Current Zoning: B-1SCD (shopping center district, conditional).
Proposed Zoning: CAC-1(CD) (community activity center-1, conditional)

Approximately 1.98 acres along the west side of Carmel Road, north of Carmel Commons Boulevard, and south of Pineville-Matthews Road.

The petition proposes the development of up to 38 multi-family attached dwelling units. The site is currently developed with a surface parking lot.

STAFF RECOMMENDATION

SITE PLAN

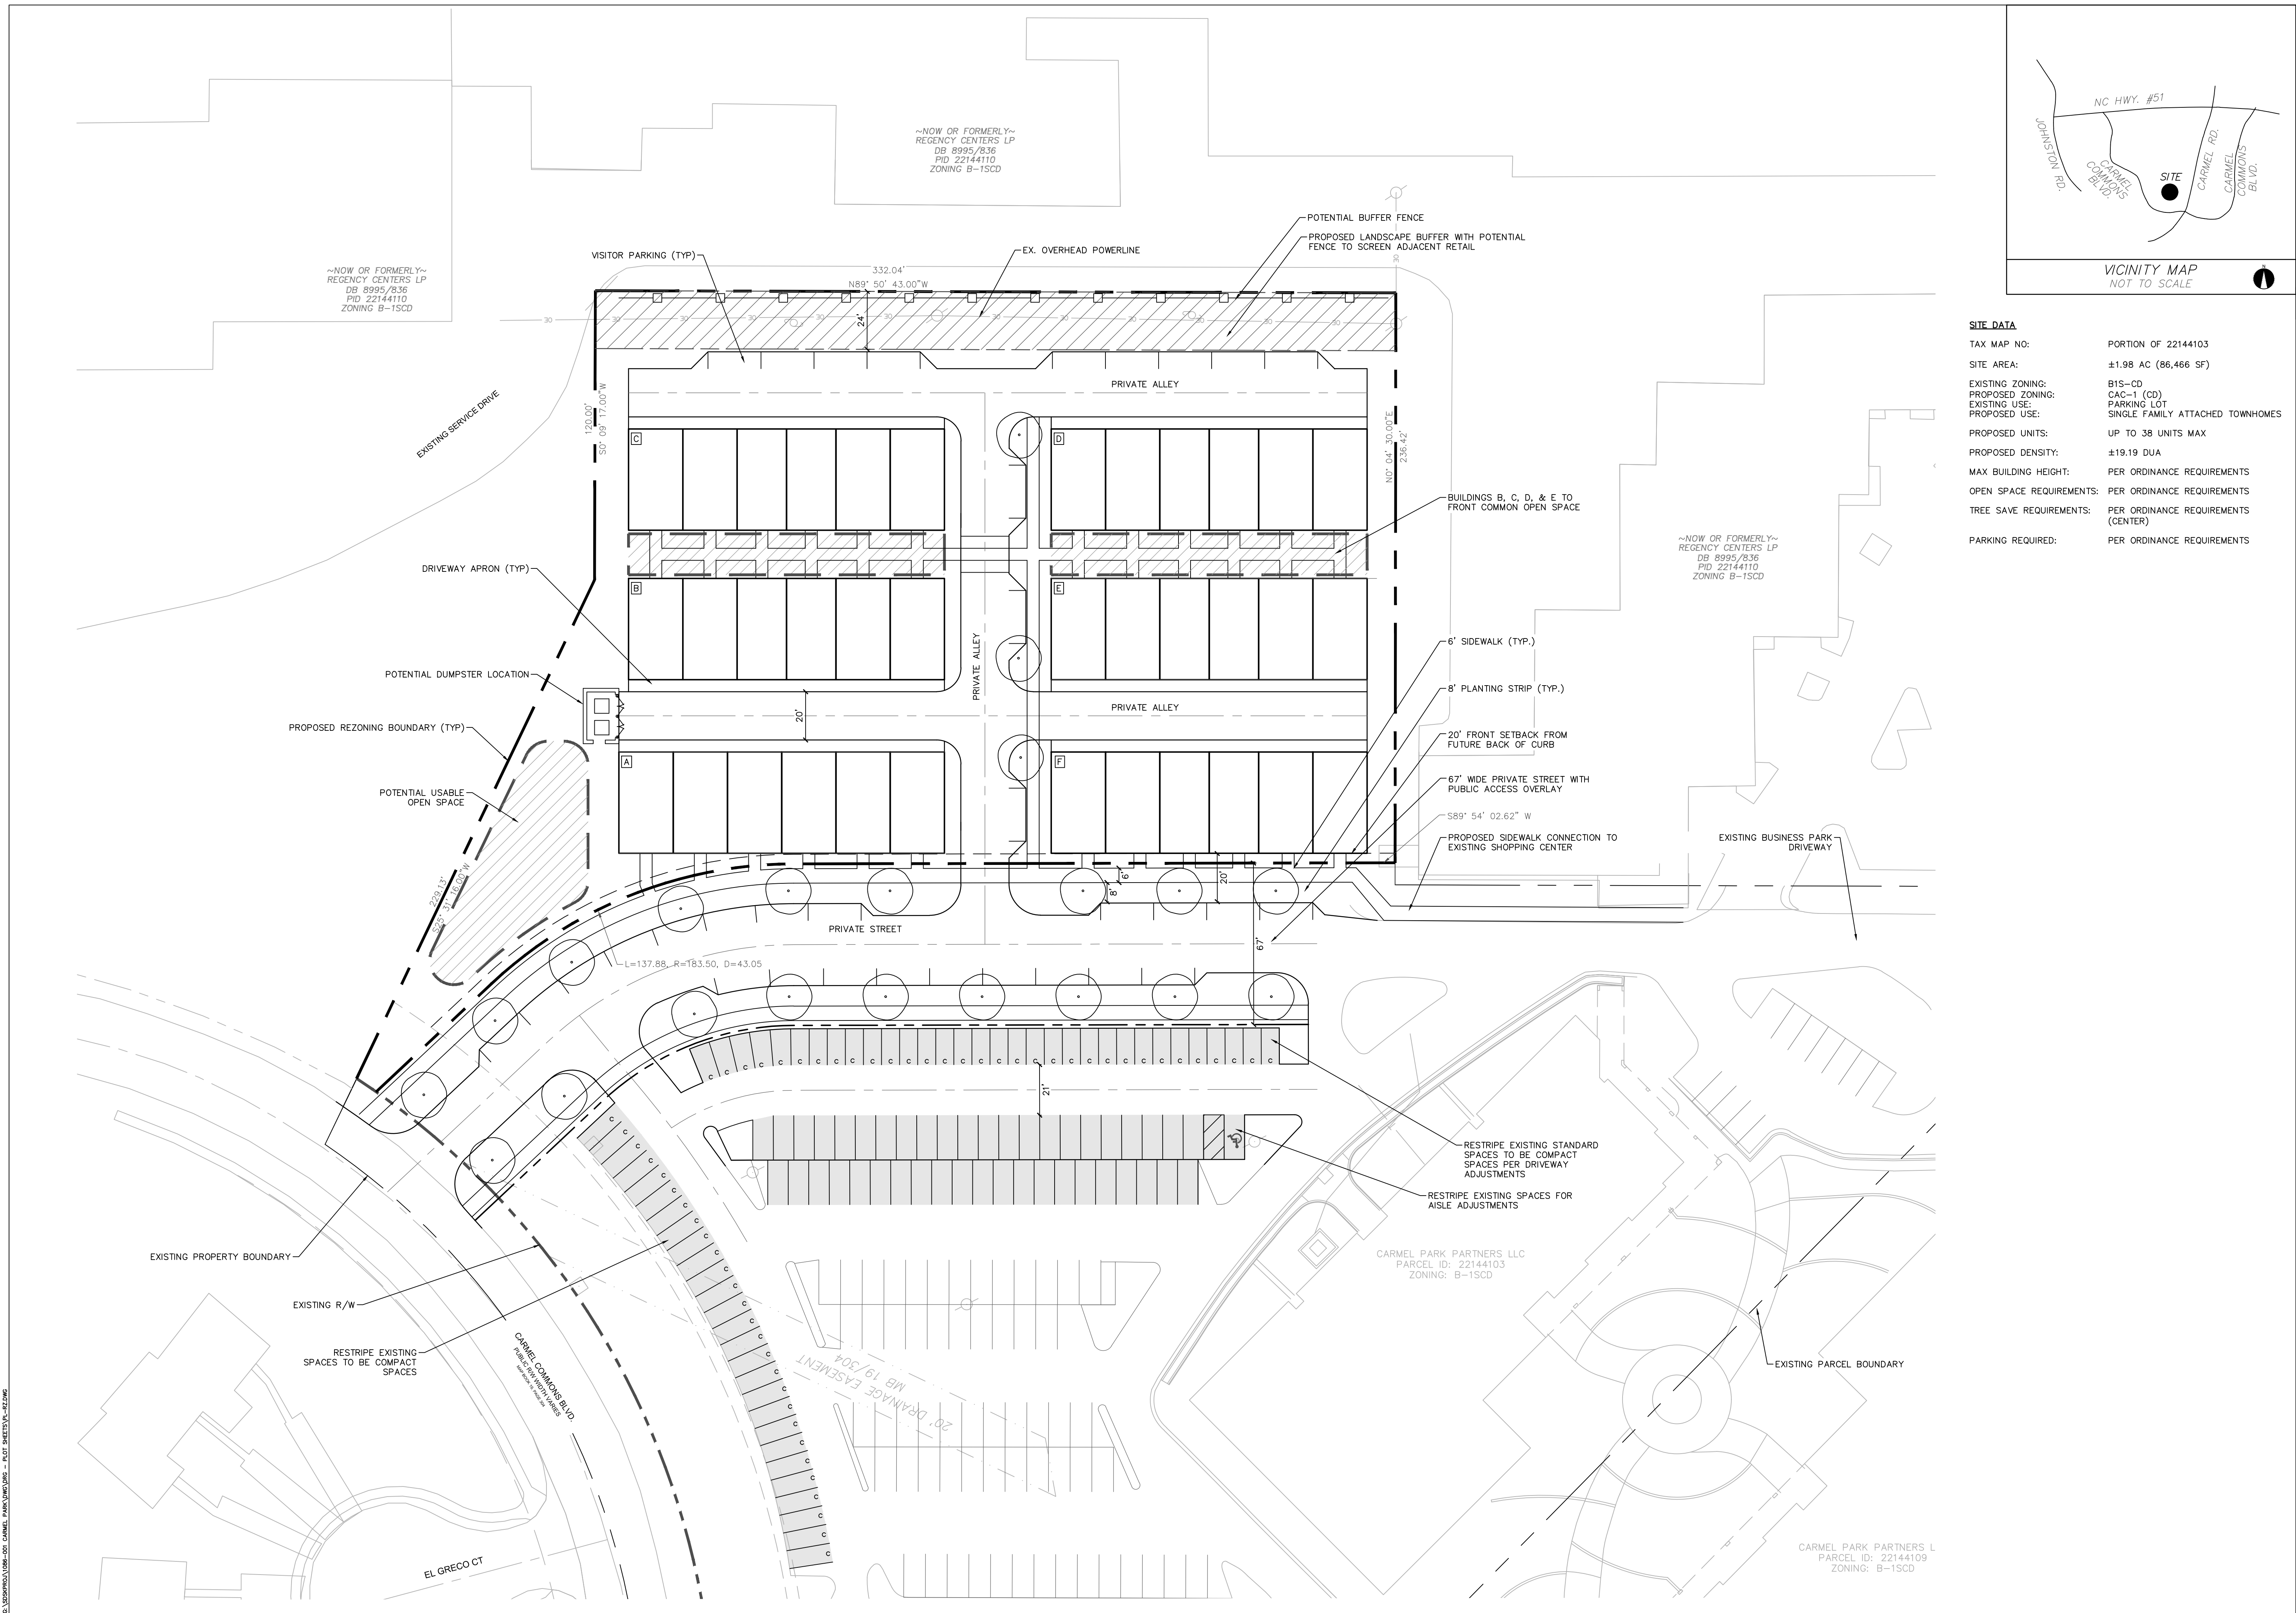
1. Entitlement Services: a berm along the rear (north) property line should be included to replace the existing berm and better screen the development from the shopping center.
2. Entitlement Services: a minimum number and maximum spacing trees to be planted along internal alleys should be include.
3. Entitlement Services: Note regarding existing parking count, and how this development will impact the prior B-1SCD rezoning plan's parking requirements, should be clarified.

4. Entitlement Services: Maximum building height is stated as 50 feet site data table and 52 feet in conditional notes. Please rectify.
 5. Entitlement Services: Revise boundaries of rezoning to include proposed improvement to private street.
-
